| Application number: 2025/90099   |                                                                                  |
| What is the application for?:    | Erection of single and two storey extensions to the side, front and rear and for |
| Address of the site or building: | 7, Bradley Grange Gardens, Bradley, Huddersfield, HD2 1QX                        |

| Type of comment: An objection

PROPOSED FIRST FLOOR PLAN Scale 1:50

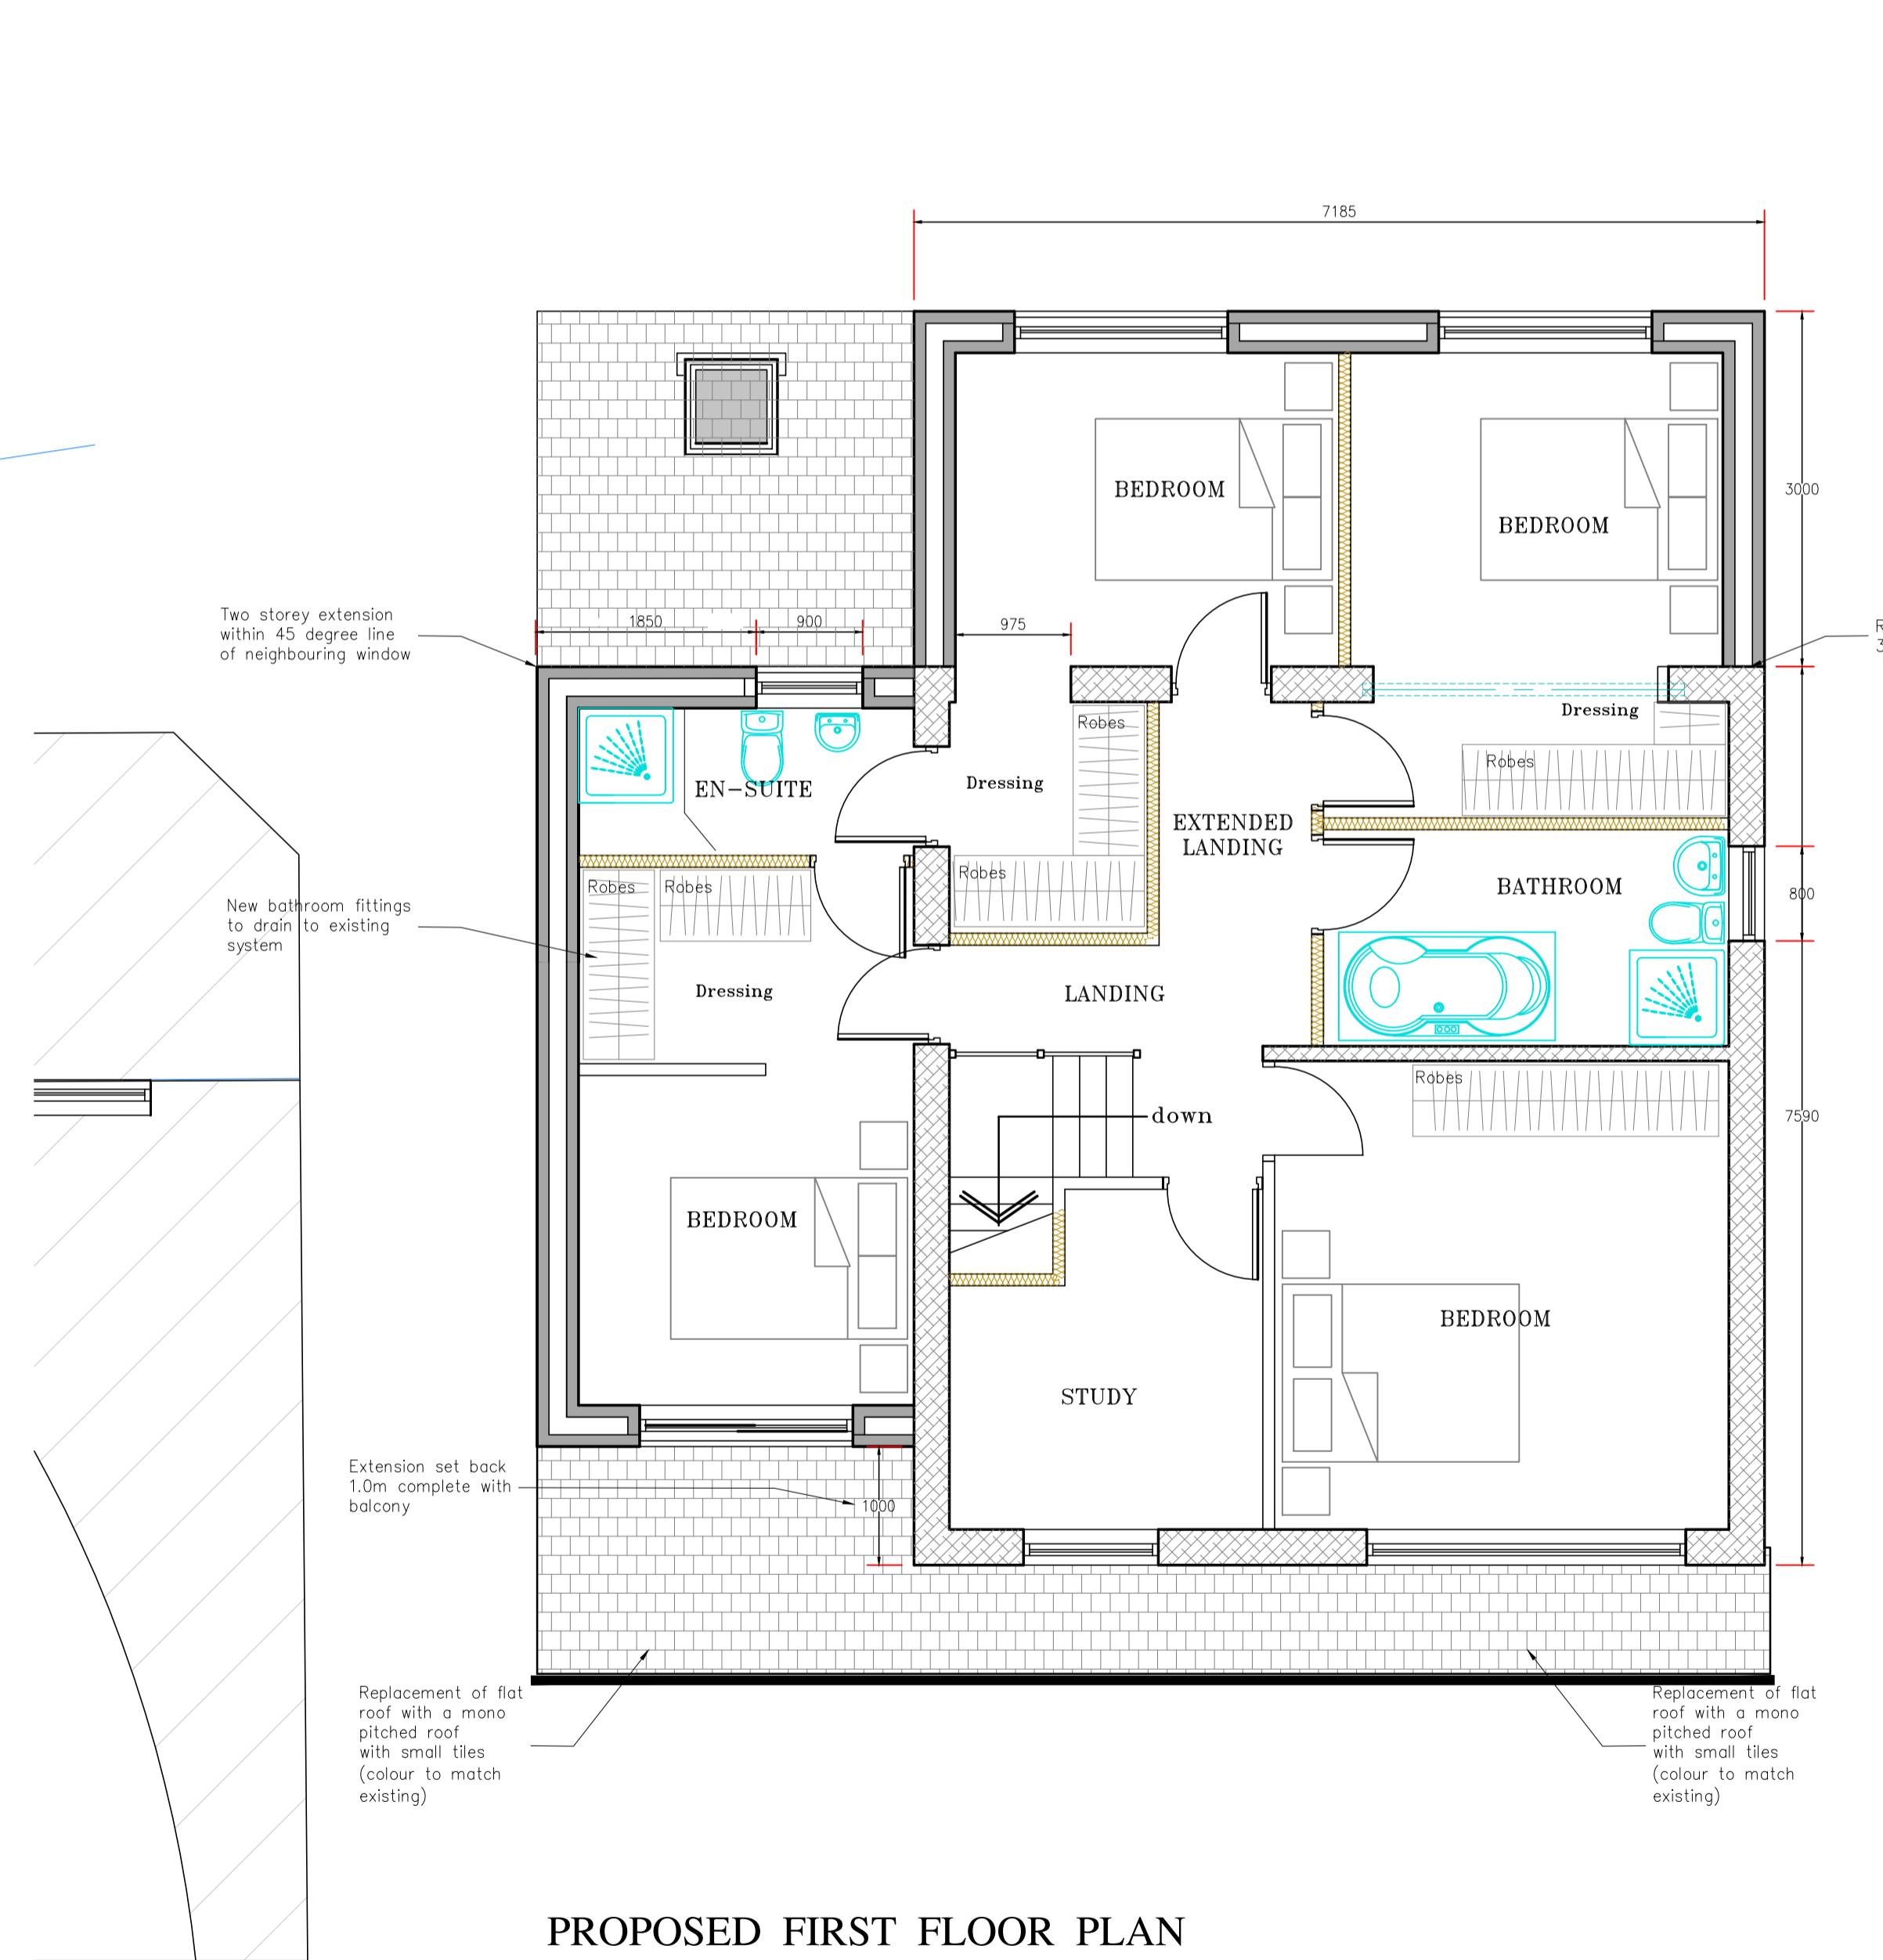
| <p>We wish to object once again to number 7's planning application for the below reasons:</p> <ul style="list-style-type: none"><li>• Too large for the plot to be in keeping with the streets character.</li><li>• Reduction of green space around the property, impacting on local wildlife and overall appearance.</li><li>• There are large conifer trees at the back of the property which are within falling distance of the new proposed plans. These are not listed on the planning forms. Are these to remain? If removed, they will remove any privacy the rear property have from such a large extension. Also impacting on local wildlife.</li><li>• The rear two story extension would significantly impact on the already limited natural light entering number 9 Bradley Grange Gardens Side bedroom (Dorma window to the left of number 9) making the room cold and dark. Increasing energy bills to heat and light the room throughout the day.</li><li>• Upstairs bathroom proposal continues to look directly into my young daughters bedroom which has an open plan shower room. Highly inappropriate to be overlooked, regardless of new plans to have concealed glass. This becomes obsolete once the window is opened.</li><li>• Number 9's window does not have privacy glass as there has never been a need to fit privacy glass due to not being overlooked. Plus, the fact privacy glass again would darken the room and a cost we would have to incur.</li><li>• Concerns regarding increased noise affecting number 9's side bedroom, with a window direct opposite young daughters bedroom.</li><li>• New proposed balcony is not in keeping with the area. Will it be a functional balcony? Or decorative?</li><li>• The plans show the redirection of the underground soil pipe. We have lived here since 2020 ( and my parents 30+ years prior) and there has always been issues with these pipes getting blocked. The new proposal indicates bends in the flow of the pipe, which will increase further risks of problems with the drainage systems.</li></ul> |    |

- The new plans do not appear to have changed, other than the front left side extension being reduced slightly. No consideration has been taken by the planners to review any previous comments made by neighbours who this would affect.
- Number 5 and 9 Bradley Grange Gardens gardens would continue to be overlooked, overshadowed and spoiled by such a large and protruding extension.
